RE: PLANNING APP: 3/2012/0256 SLURRY LAGOON AT WATT CLOSE FARM, GISBURN

Please be advised that Gisburn Parish Council wish to object to the above application.

PLAN VIEW OF PROPOSED LAGOON

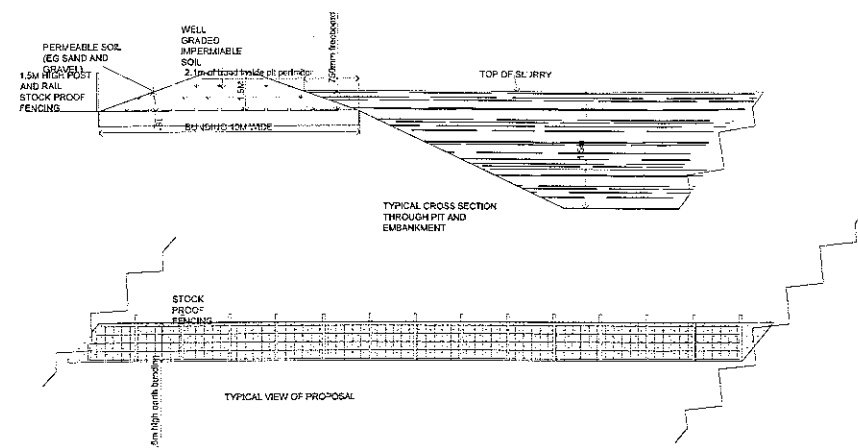
The Parish Council do not understand why the applicant has chosen this location for the lagoon and believe it should be located nearer the farm itself. Any potential leakage from the lagoon in the chosen location would affect neighbouring landowners rather than the applicant.

The Parish Council are also concerned that any potential leakage, from the chosen location, could easily enter a local watercourse and for this reason also believe another location should be chosen.
